From: Simon Davis <Simon.Davis@arun.gov.uk>
Sent: 21 April 2020 12:47
To: Planning.Responses <Planning.Responses@arun.gov.uk>
Subject: FW: BE/137/19/RES The Cottage, Shripney Road

Consultation Response from ADC Cleansing

WSCC Highways had stated that “Tracking is demonstrated for a 9.86 metre refuse vehicle. Although no over-running is indicated, the tracking is very tight to the kerb with very little margin for error. This aside, it must be confirmed with the Arun DC waste collection team that the correct vehicle dimensions have been applied and that the collection arrangements are acceptable.”

Drawing 160818-TK04

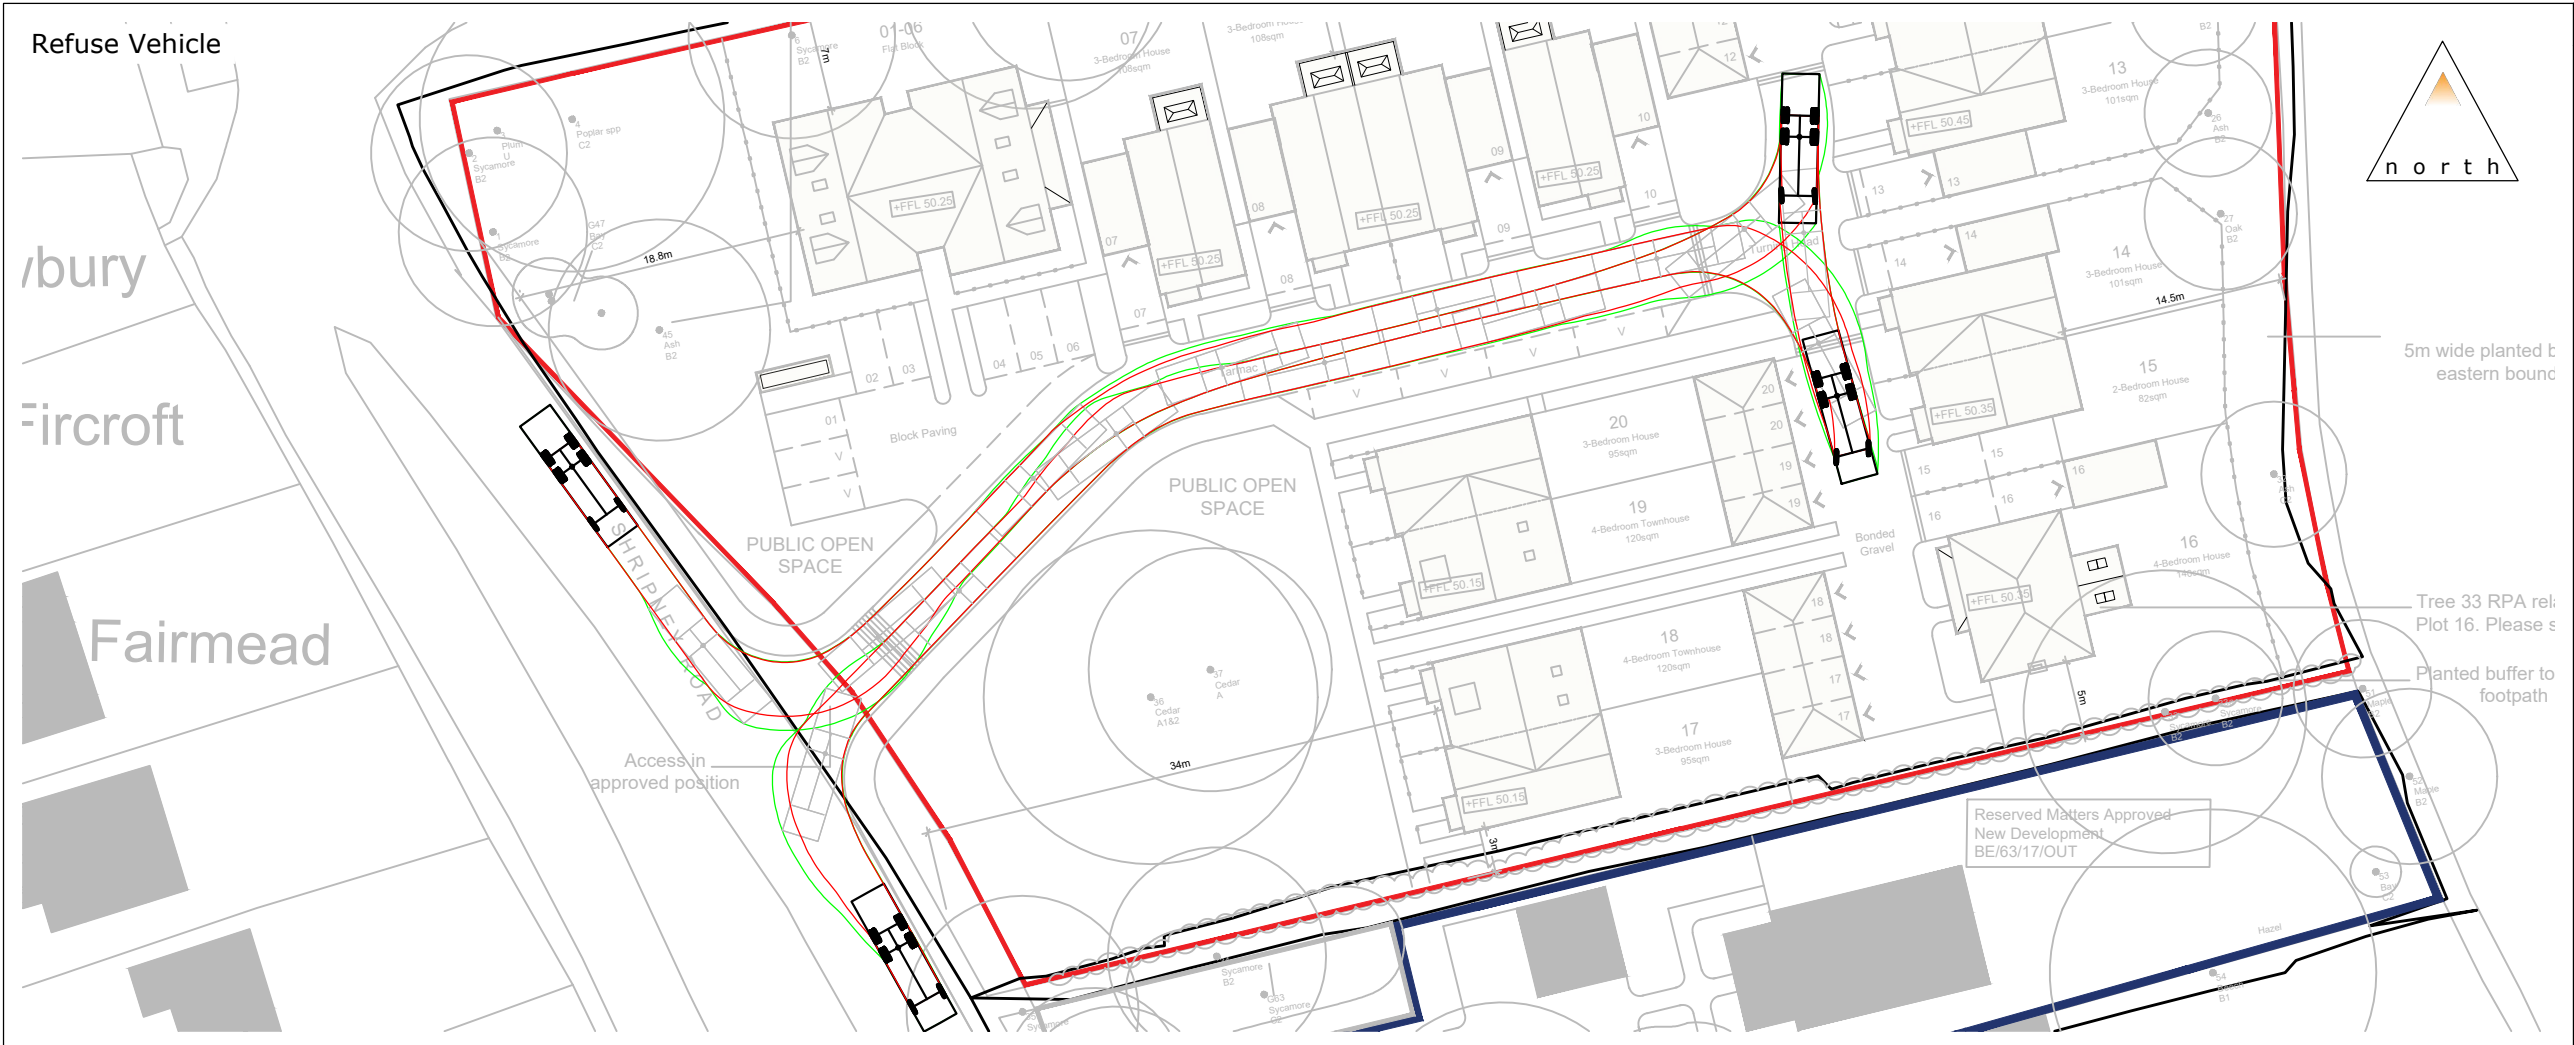
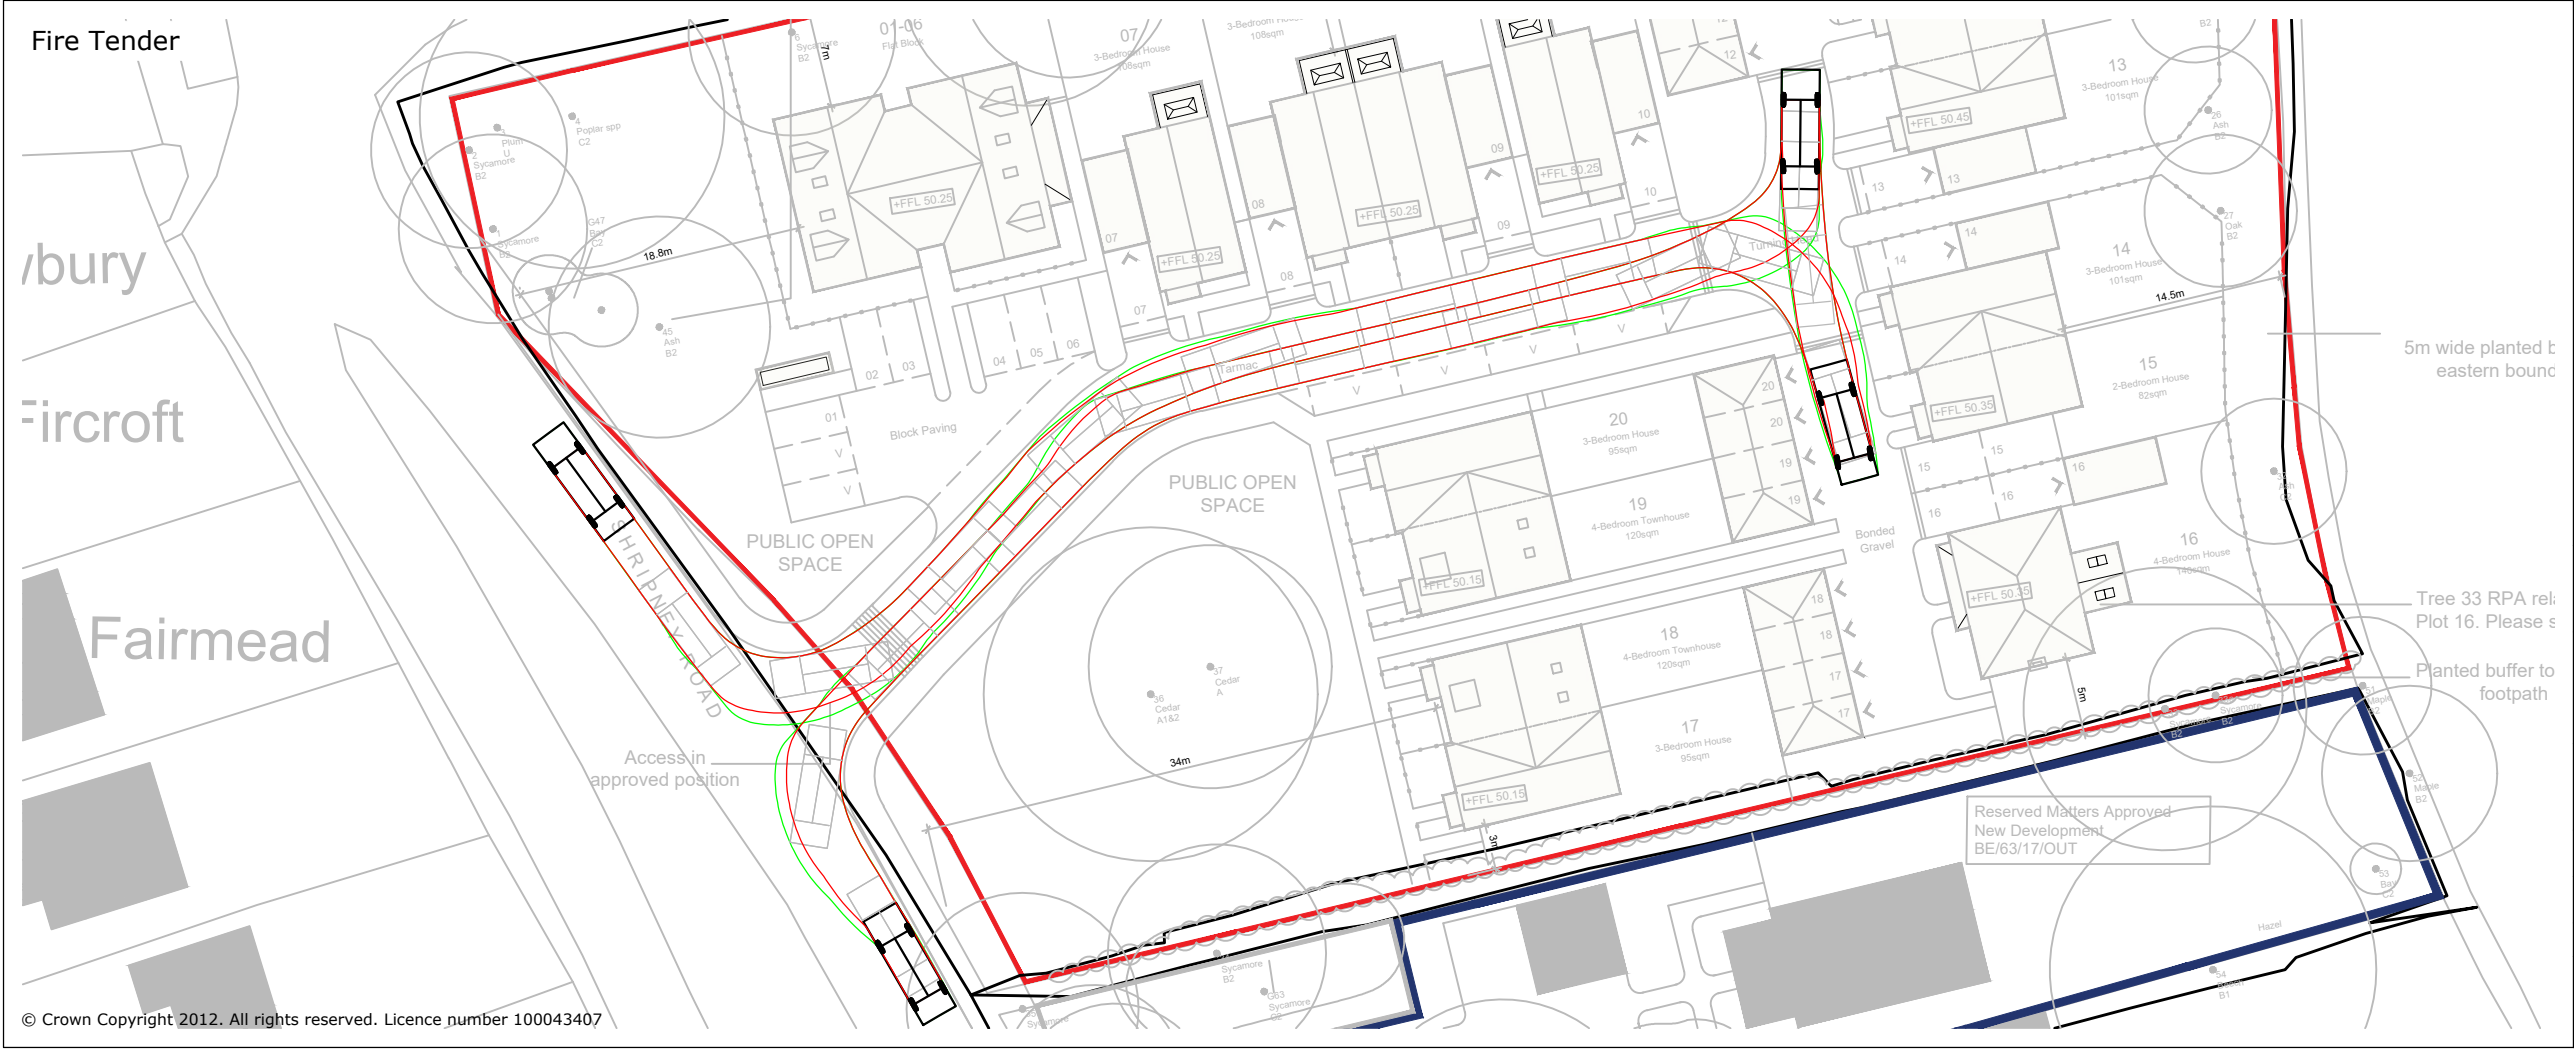
Hi Dan,
The dimensions are about right – I have attached documents relating to Turning radius for our vehicle. Looking at the map you attached it all looks ok, but as with all these developments a lot depends on how the residents park. It

might be worth pointing out that any block paving would have to be able to withstand the weight of the vehicle making a tight turn into and out of the turning area – this would put down a fair bit of “scrub” from rear wheels.

The attached plan has been amended since to widen the block paving turning head to 4.8m. Can you let me know if the layout is suitable for a refuse vehicle.
